From: Martyn White
Sent: 22 February 2019 09:07
To: Planning.Responses
Cc: Zac Denton
Subject: A/4/19/HH & A/5/19/L

A/4/19/HH & A/5/19/L

The proposal is for an extension to an existing garage. The garage is located within the grounds of 'Weavers' which is a grade II Listed Building. Weavers is itself a two storey flint faced cottage with red brick dressings and quoins. The windows are timber casement.

Client	Description
J ANGLICE ANGEL	EXISTING AND PROPOSED

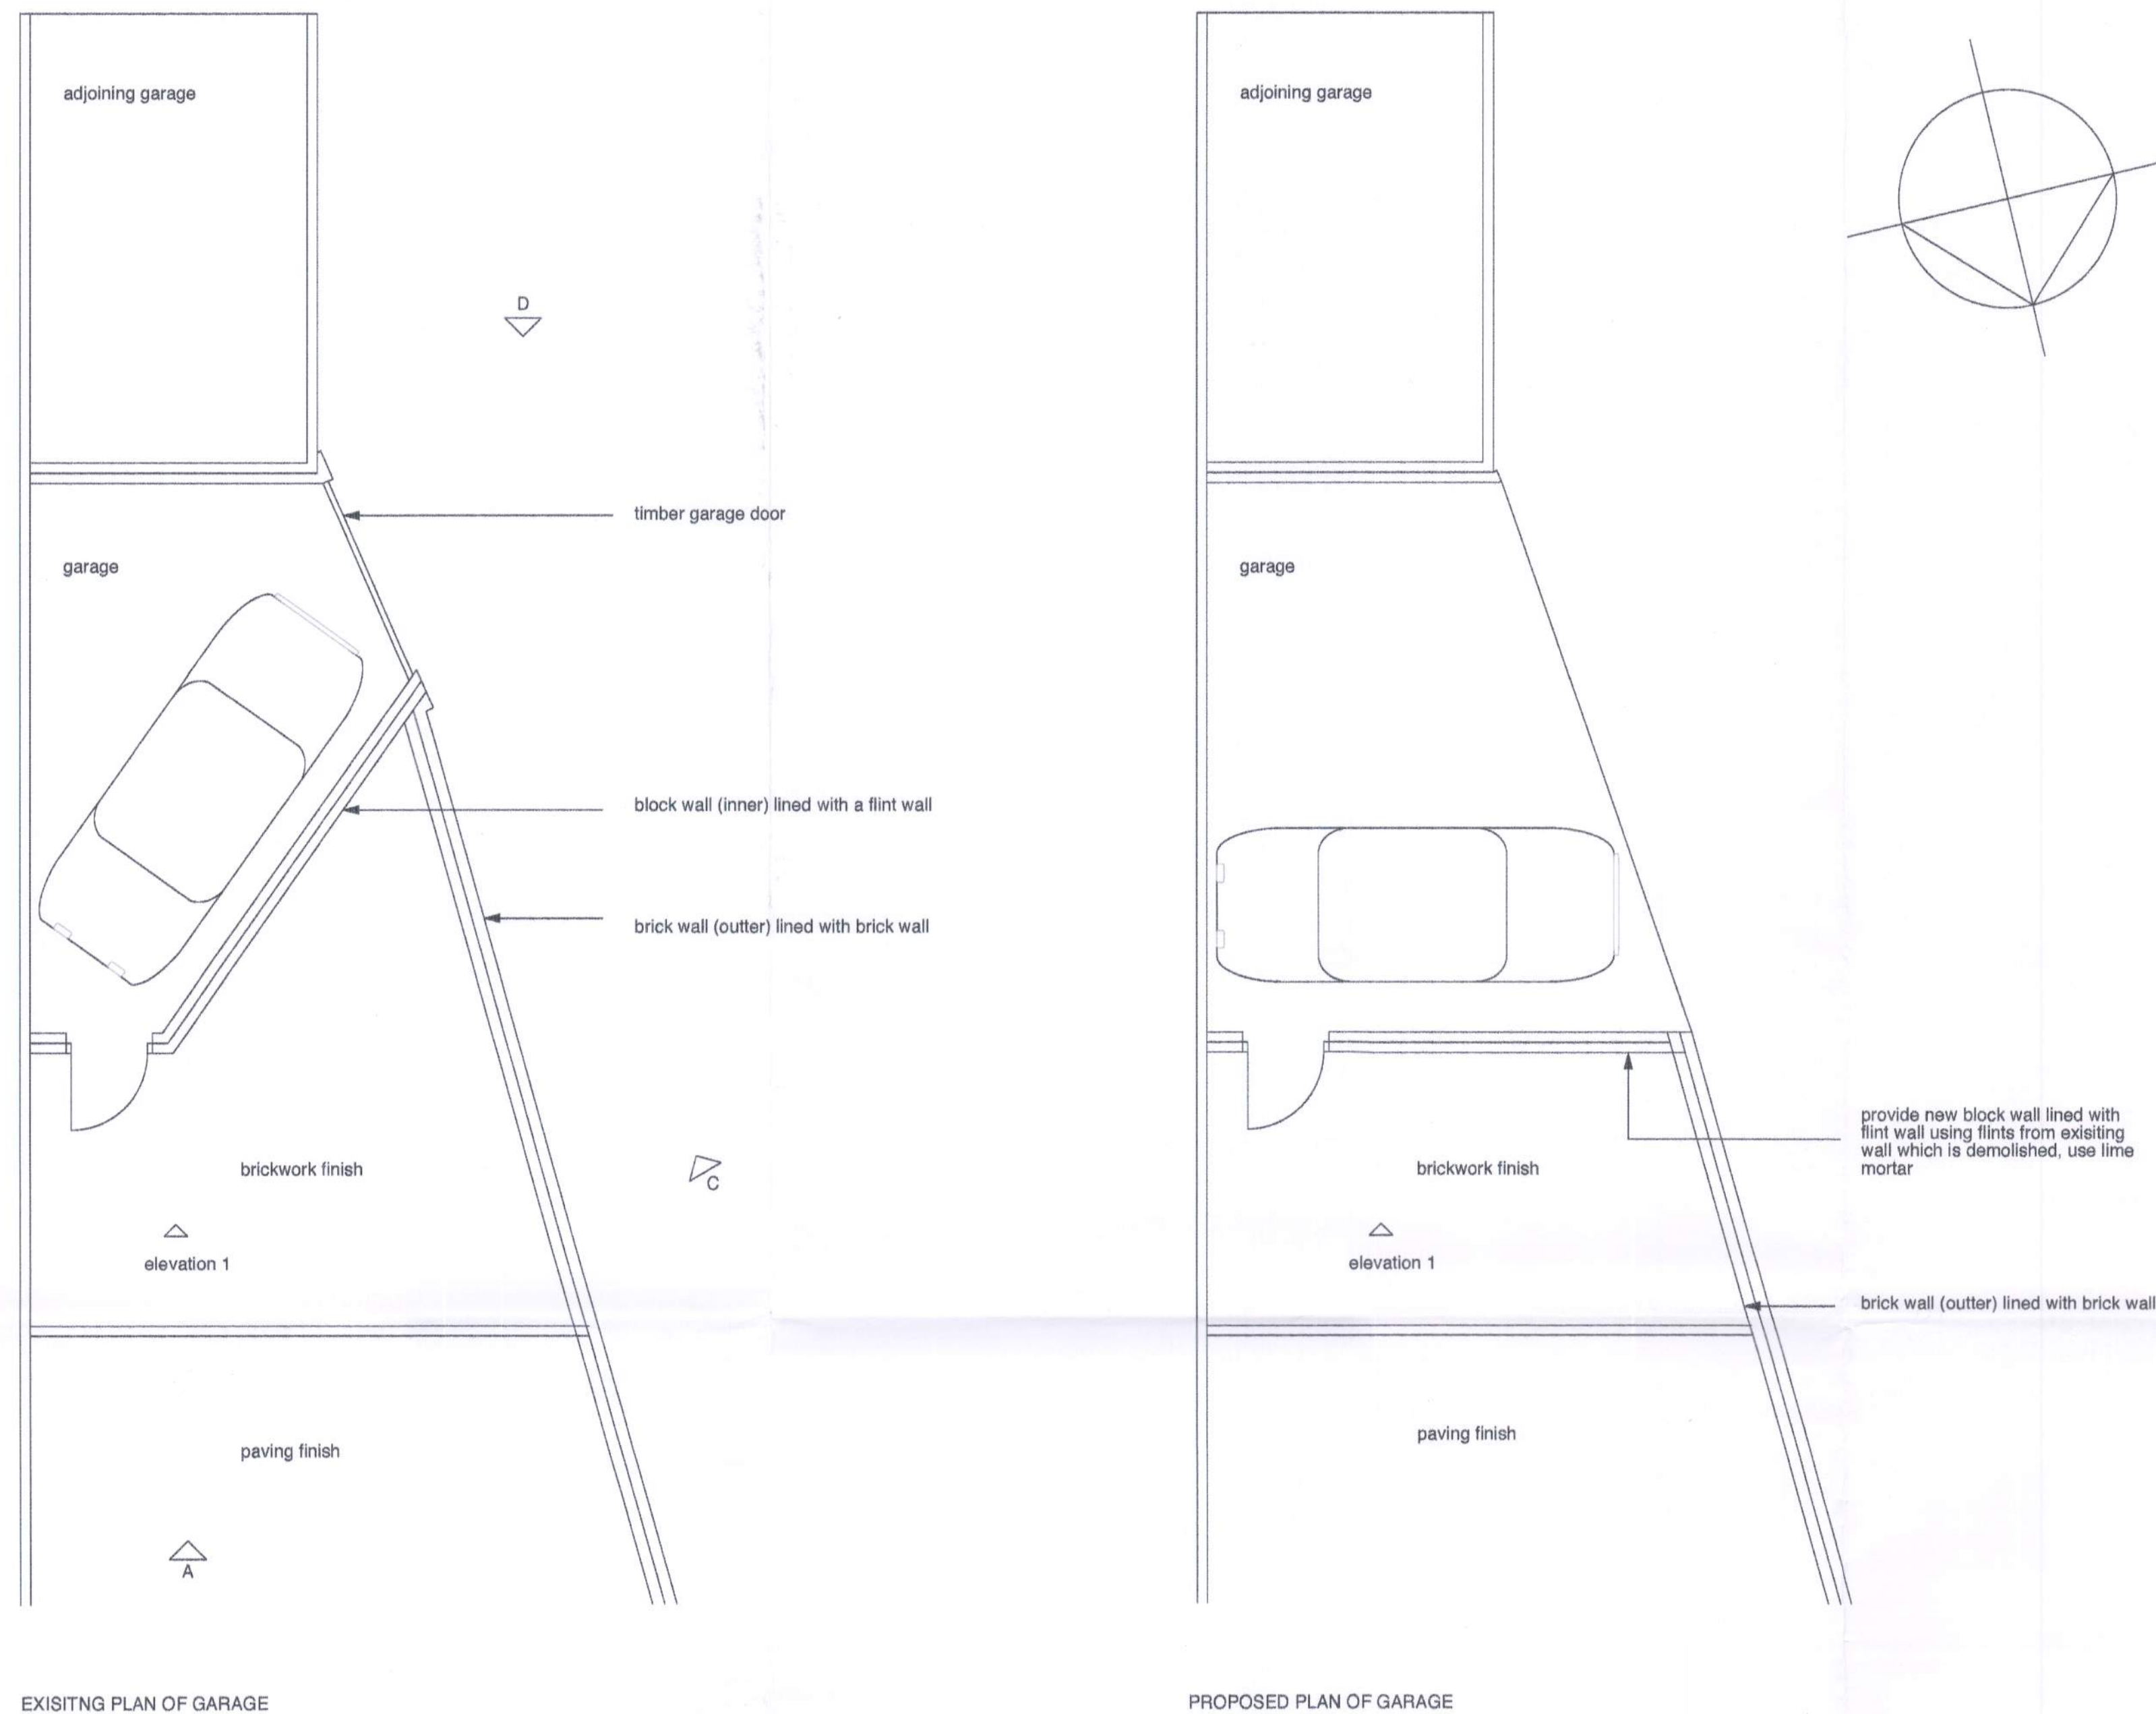
The proposal to extend the garage therefore appears to affect modern material which is of no significance. Further, the proposal removes an unusual shaped structure in the grounds of the listed building which can be supported. The use of the existing flint is positive and should be provided so that it reflects the quality of the existing walling.

Of some concern is the proposal to leave the larger garage open to the lane. Such a proposal will leave any contents exposed to the lane, which could potentially be unsightly. Is there a reason why replacement doors have not been proposed?

If minded to approve such a scheme, materials should match existing, and all existing flint should be retained and re-used.
